SUBMISSION

St Aloysius College Redevelopment SSD Application Number SSD 17_8669

My comments are in relation to the Junior School site.

Phase Three: Junior School

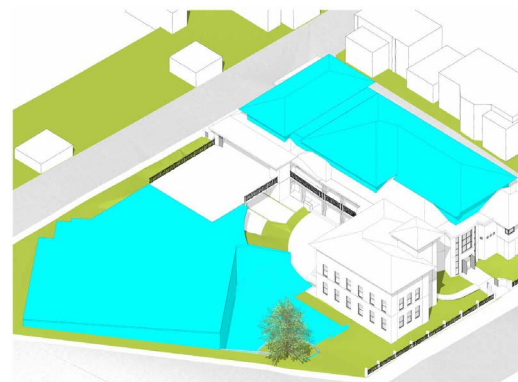
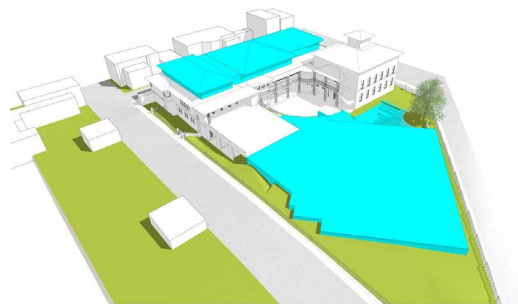
In approving the Junior School Concept Plan the School will be given an automatic future right to build an extra level on the school building, excavate and construct a basement level multi-purpose hall and create a new basket-ball court and stands, without showing and considering the impact on residents. As a resident that backs onto Crescent Lane, that is something that we will not know the final outcome for a number of years.

- Excavation (e.g. vibrations, stability, need for stability ties into neighbouring properties, excavation noise, dust). In the process of the bore holing for geotechnical testing, there was considerable vibrations caused – the proposed excavation would be a lot larger and longer than this.

I object to the excavation proposed in the Junior School Concept Plan as there is no detail about impact on neighbouring properties and plans for construction.

It is not clear on the plans where the tree along Bligh Street & Crescent Place are staying or being removed. We were assured by the school at the Precinct meeting on May 3, that they were staying, and yet on close inspection of the plans, they are marked for removal, and would be difficult to retain due to the level of excavation and destruction of the roots, with the new building / excavation being so close to the road boundaries.

At the DA stage any excavation should involve preparation of dilapidation reports for each house prior to any work being approved, establishment of monitoring regimes, creation of and 'unexpected damage hot-line' and agreement by the school to rectify any damage.
